Consultation Response from KC, Highways Development Management
2026/91304 Rose And Crown Inn, 132, Knowl Road, Golcar, Huddersfield, HD7 4AN
Variation condition 2 (plans) 9 (drainage), 10 (drainage), 14 (highways) and 17 (provision of footway) on previous permission 2024/90839 for erection of 7 dwellings and associated infrastructure following partial demolition of existing public house (within a Conservation Area)
Date Responded: 24 June 2026 Responding Officer: Sheila Henley Responding Ref: 2-3NE/18

Recommendation: Additions and revisions.

Plan Ref: 3683 (0-) 10C Proposed Site Plan; 2376-0007 rev B - Highway Boundary; 2376-0006A - Bus Shelter; 2376-0005B - Typical Sections; 2376-0004A - Cross Sections; 2376-0003A - Long Sections; 2376-0002B – Contours; 2376-0001E - Kerbing & Surfacing; 3683 (0-) 08B - Plot 6; 3683 (0-) 09C - Plot 7.

Drawing No. Revision
3683 (0-) 08 B

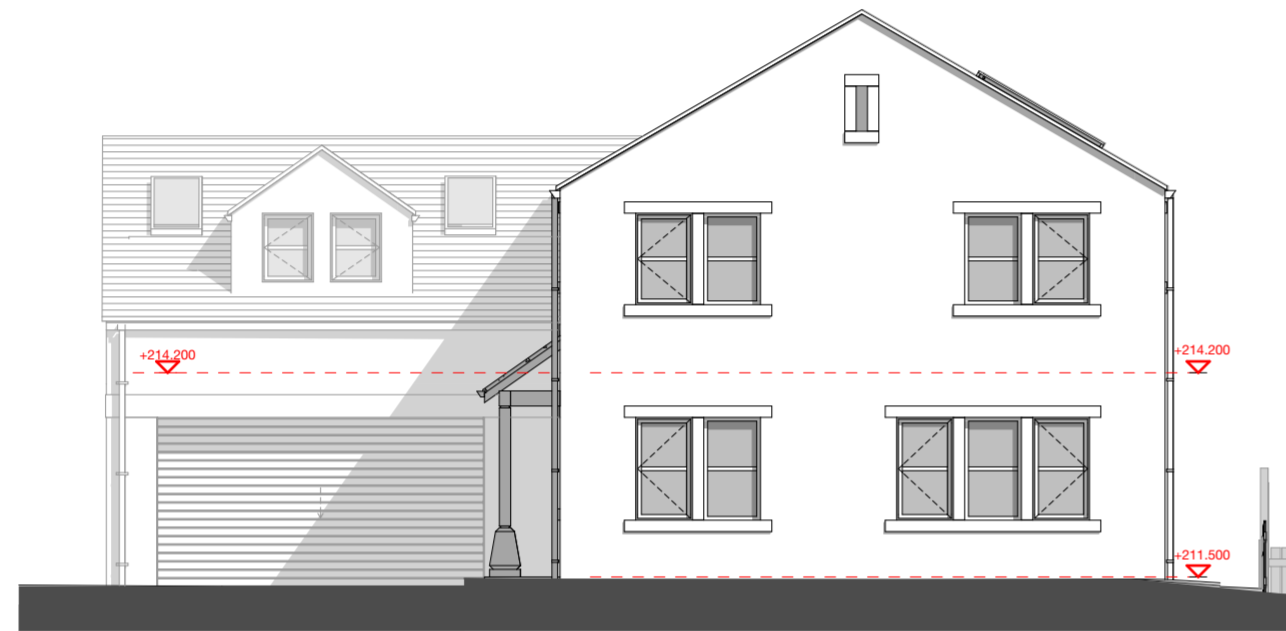
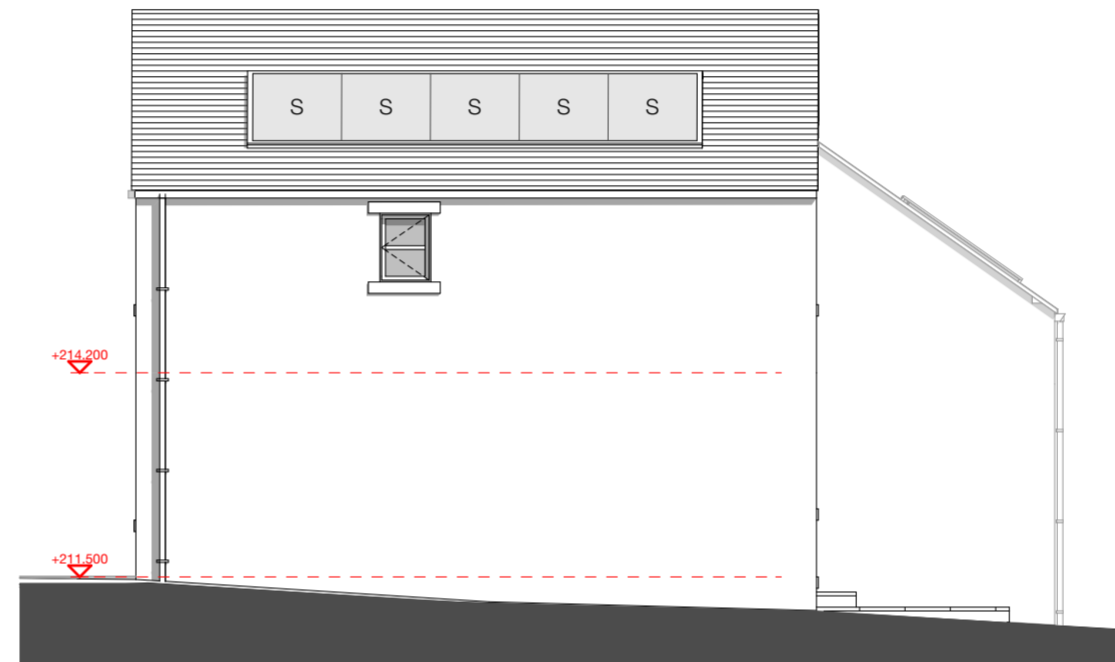
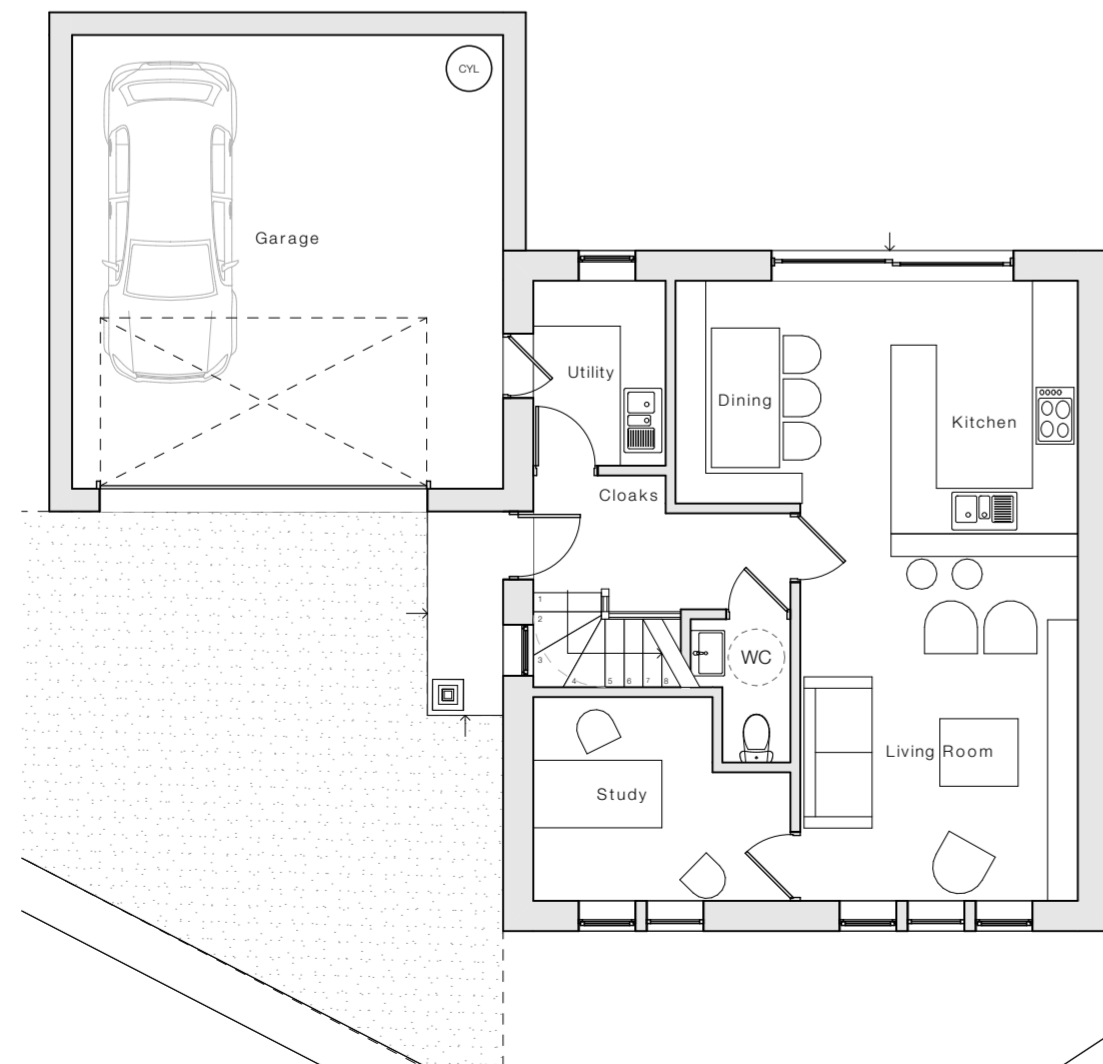
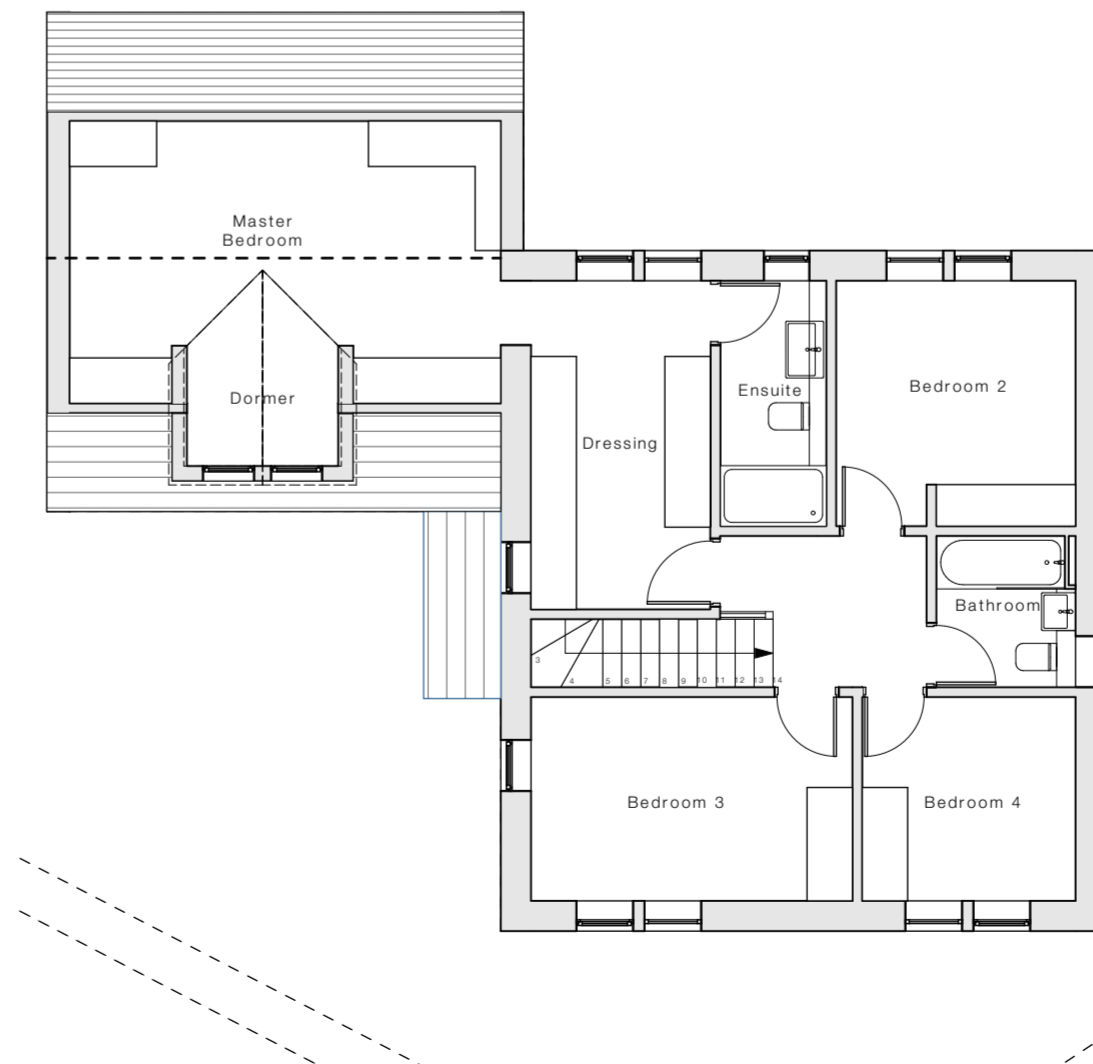
The intended double garage for Plot 6 is slightly wider internally than suggested within the Highways Development Delivery Planning Pre-Application and Application Advice Note of 6.0 x 5.0m. It would be suitable for parking of further cars and storage of cycles and other items.

Drawing No. 3683 (0-) 09
Revision C

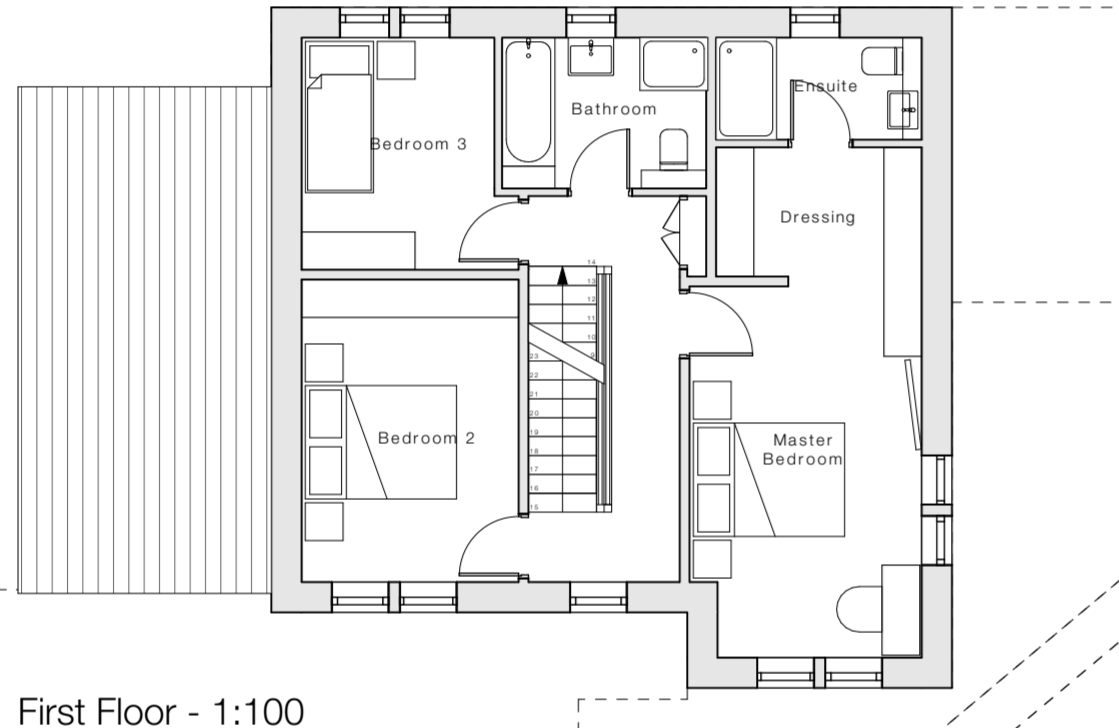
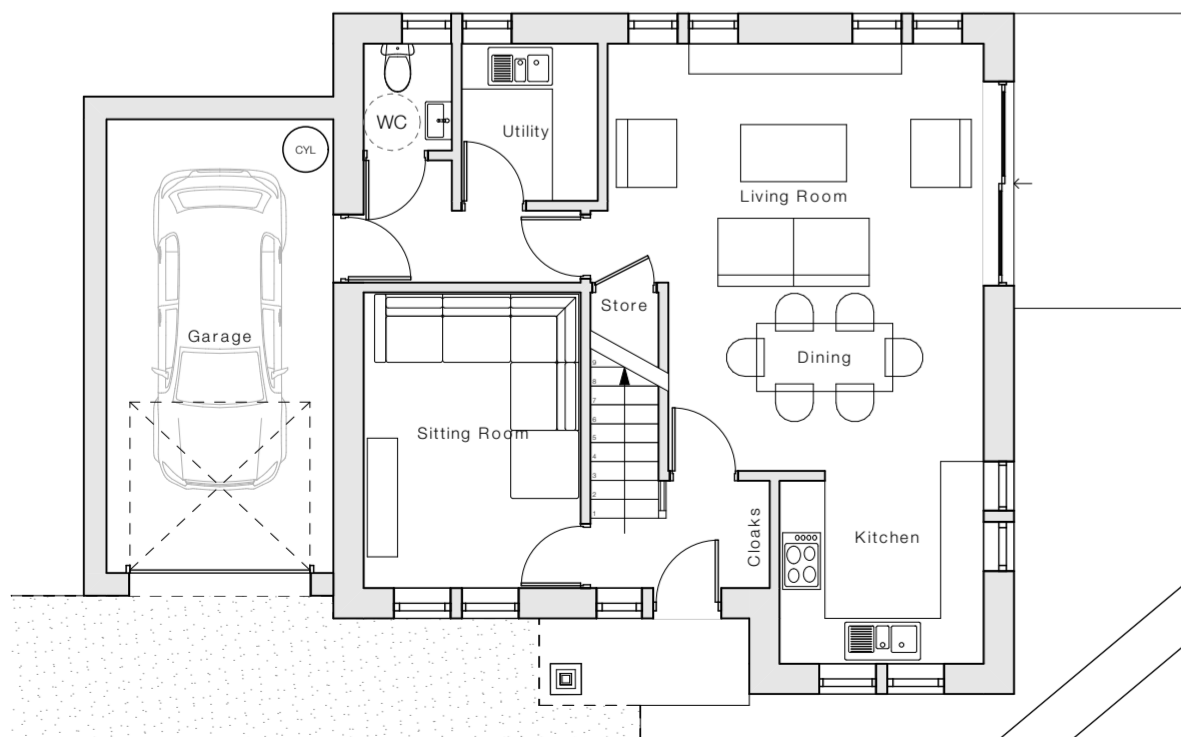
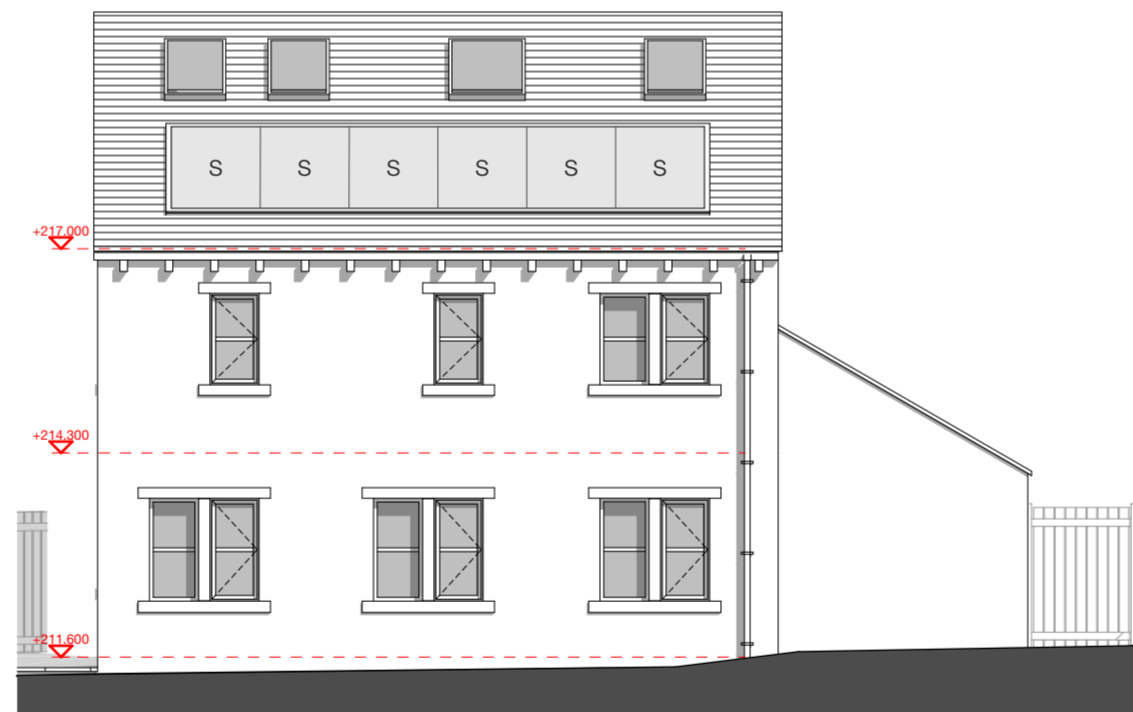
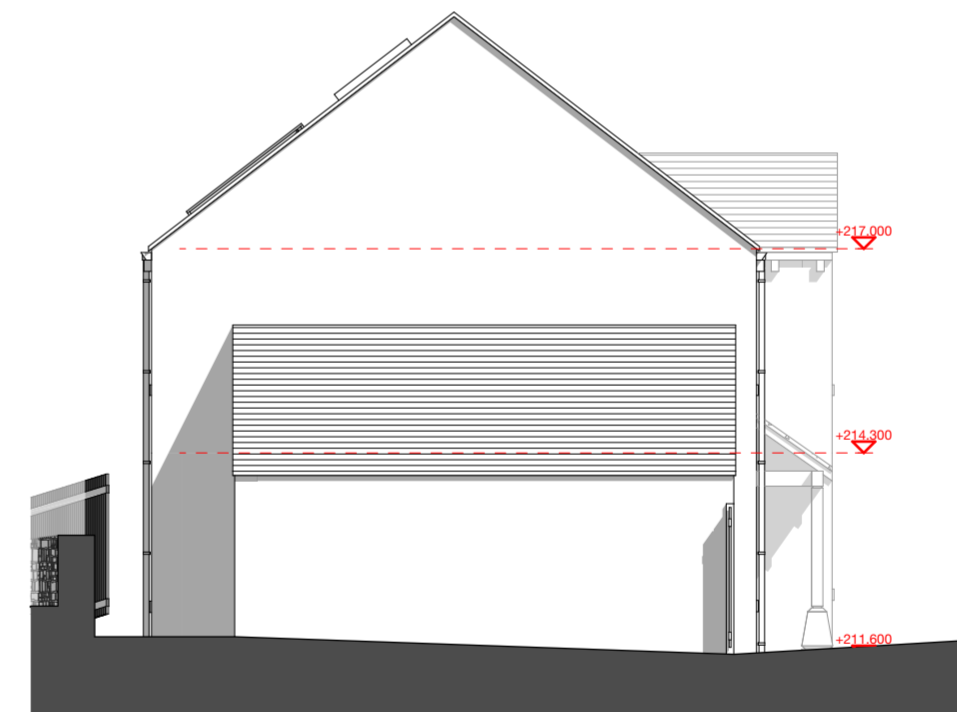
The single garage for Plot 7 is of adequate internal size too at 6.0m x 3.0m to make it suitable for parking and storage of cycles and other items.

The garages should be retained for the purposed of parking particularly for Plot 7 given only two exterior on-plot spaces when three spaces would be the norm.
